PROPOSED GROUND FLOOR PLAN

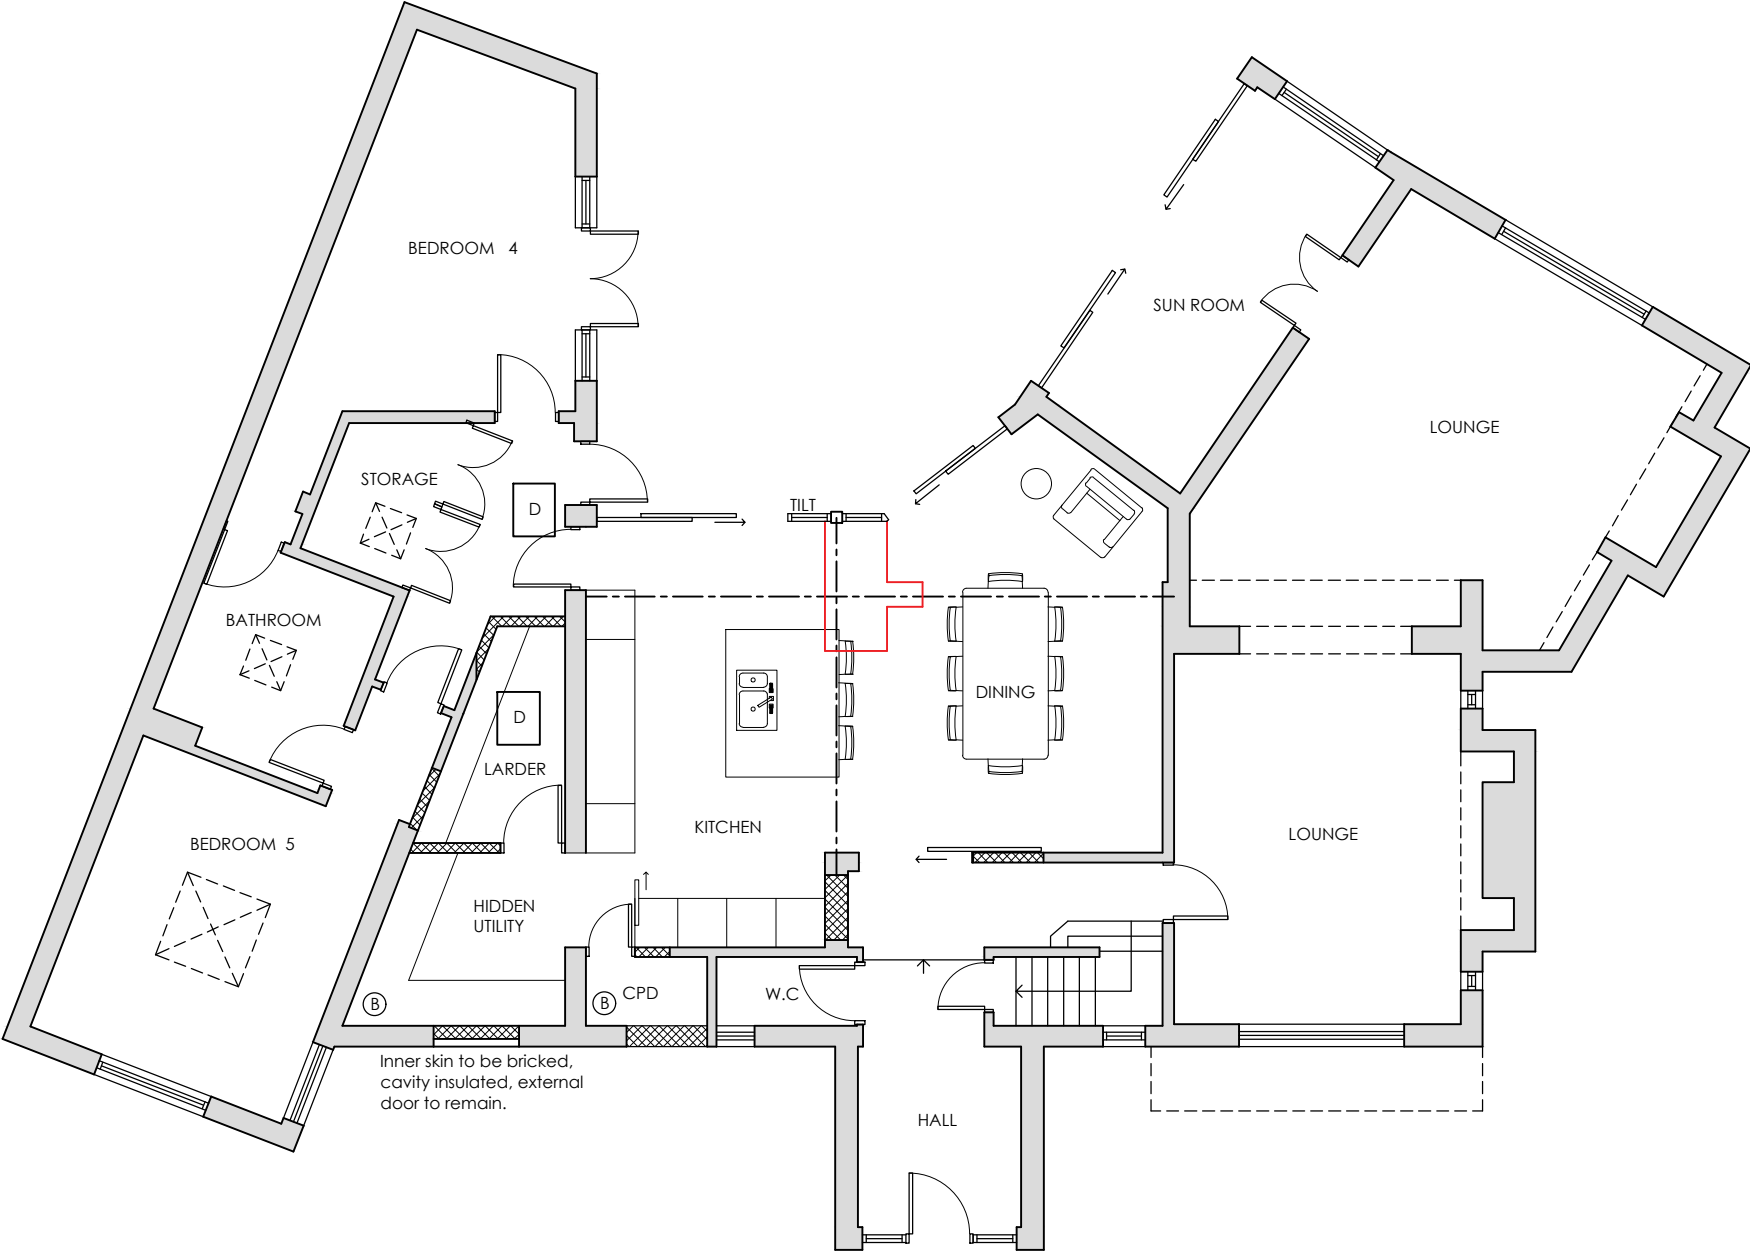
The proposed ground floor plan is inconsistent with the proposed north-east elevation. Please review and amend.

Thank you for your email, it's not really an inconsistency, just an issue of how to present the information, we have added a note to the plan in the first instance, please see attached. Is this sufficient? If not, please advise how you could like the proposed changes shown on the elevation shown on the floor plan.
